Please ask for: Sian Eggington
Email: sian.eggington@terraquest.co.uk
Telephone: 0121 2341390
Our Ref: LU/237/20/HH
Your Ref:
Date: 16th September 2020

Application for Planning Permission for Works or Extension to a Dwelling

Development: Single storey outbuilding to rear for use as a garden room.
Location: 25 Fairway Littlehampton BN17 6PY

COUNTY WEST SUSSEX		DISTRICT ARUN		© Crown copyright 1980	
ORDNANCE SURVEY		PLAN REFERENCE		TQ 0401	
SECTION Q		Scale		1/1250	
TITLE NUMBER		WSX43466

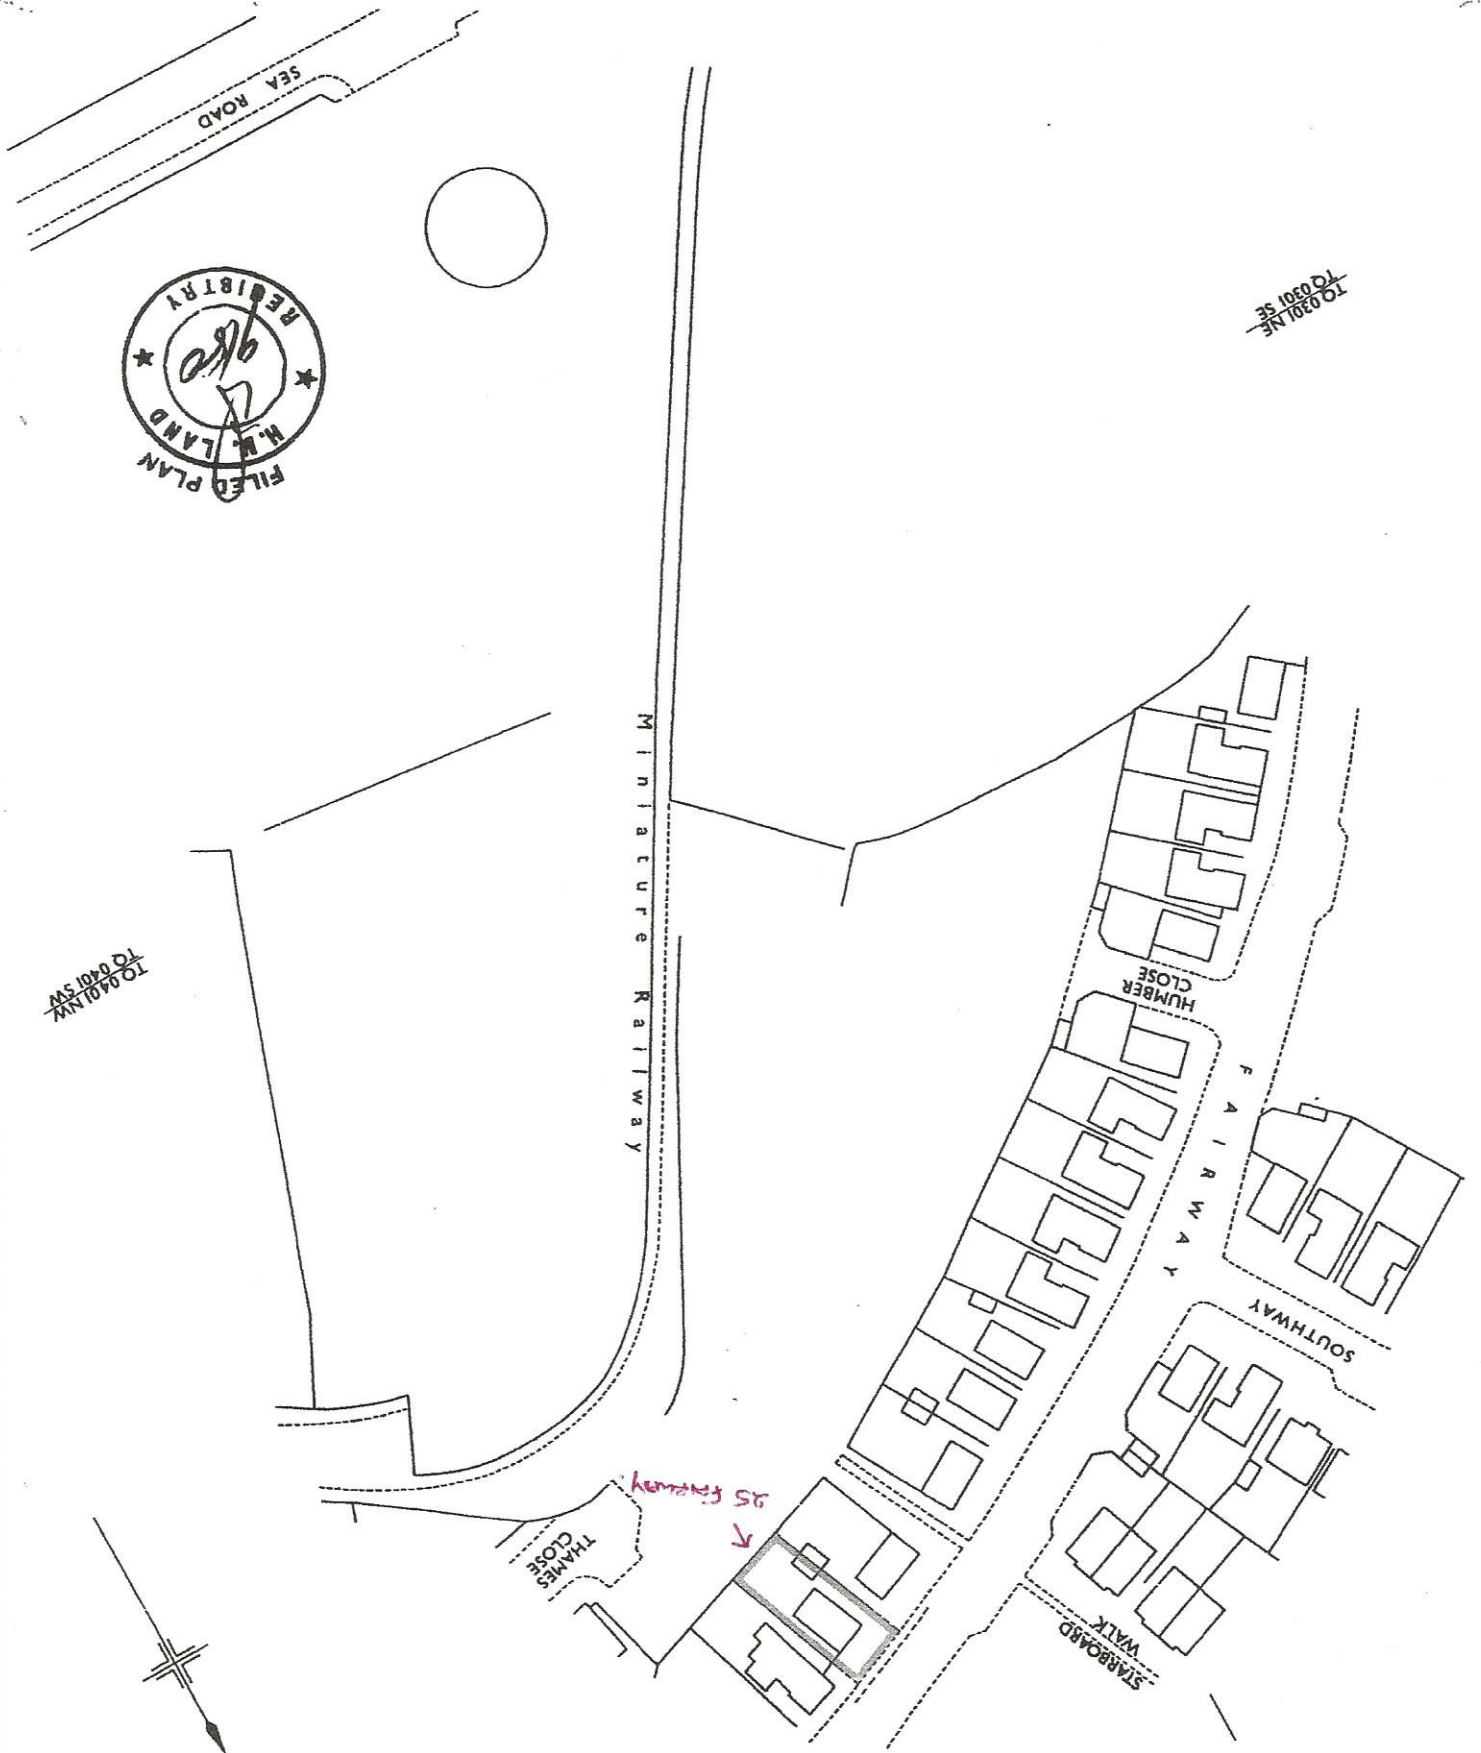
A site location plan requires a red solid outline around the site property. Please amend.

Proposed Floor Plan.

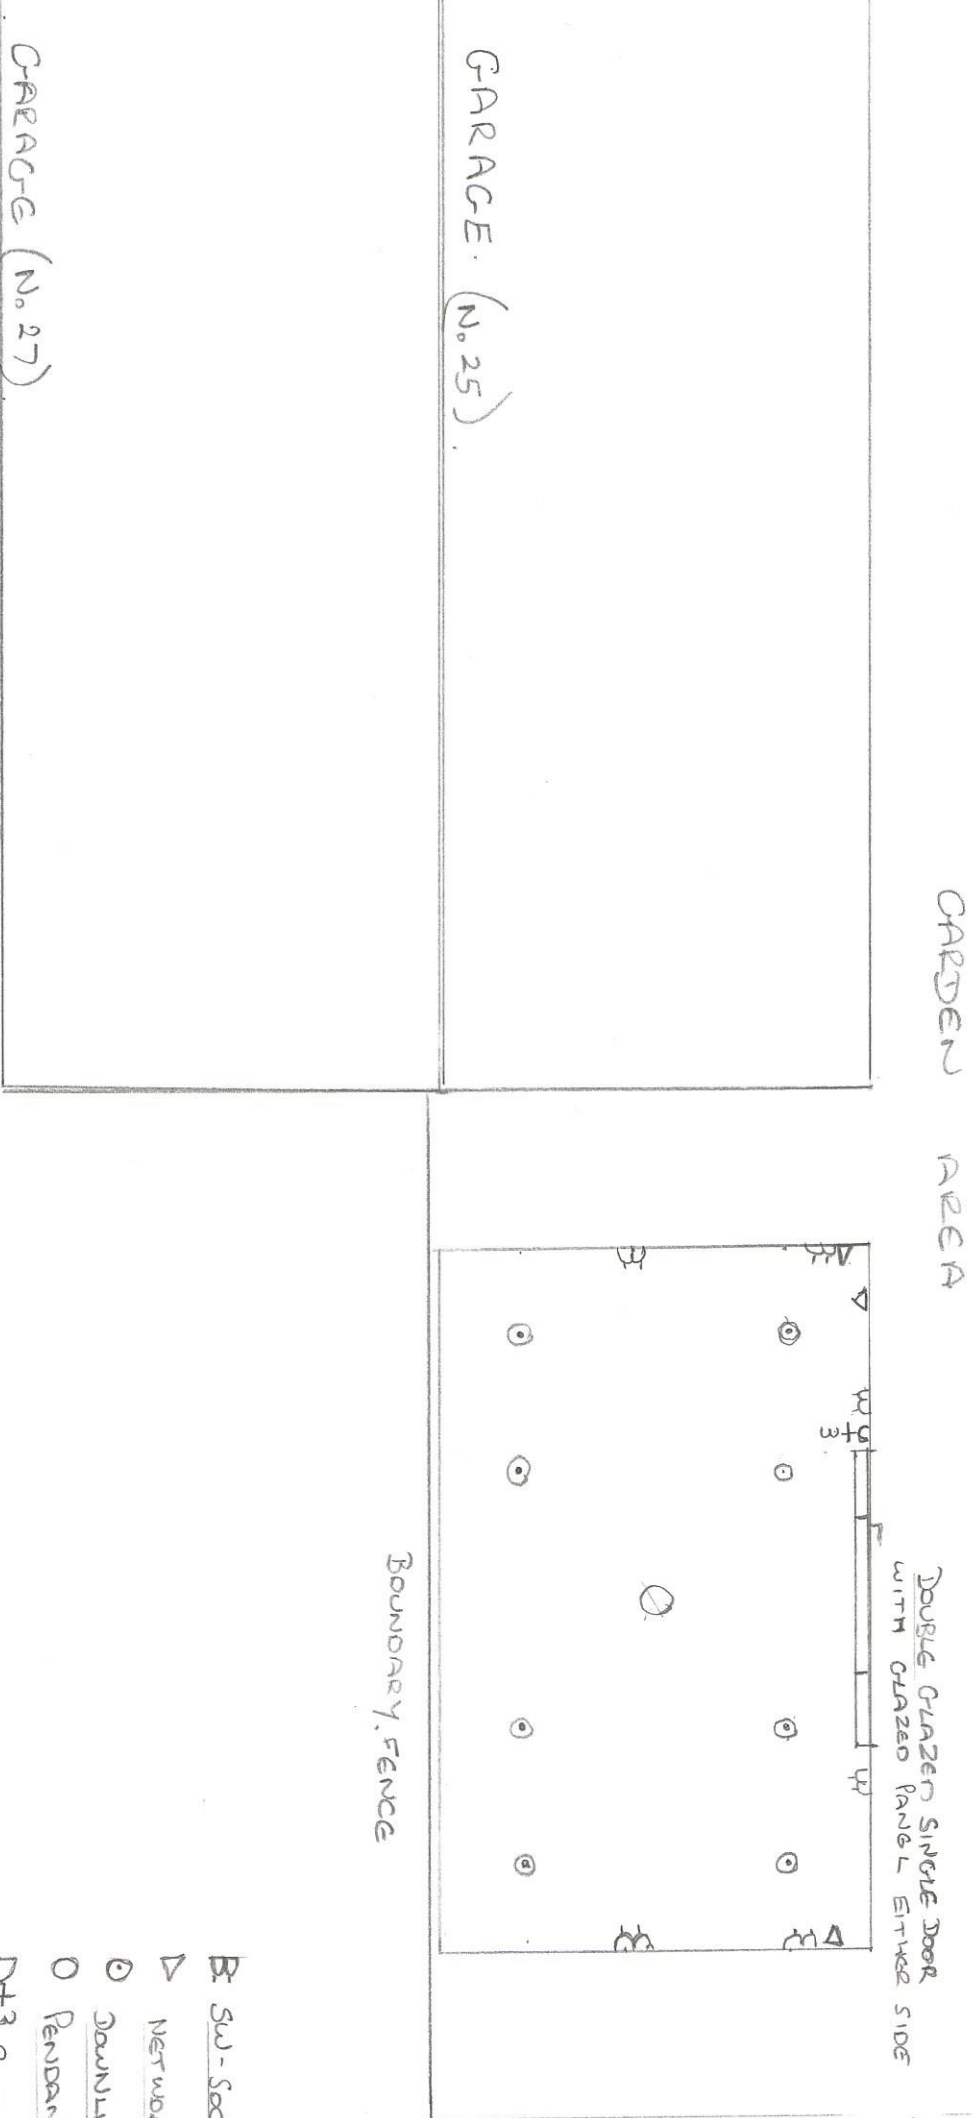
Please submit 1 electronic or 3 paper copies of clearly labelled existing and proposed floor plans at a scale of 1:50 or 1:100. Further details can be found in the Validation Requirements List.

Please amend your plans to include a scale and a scale bar.
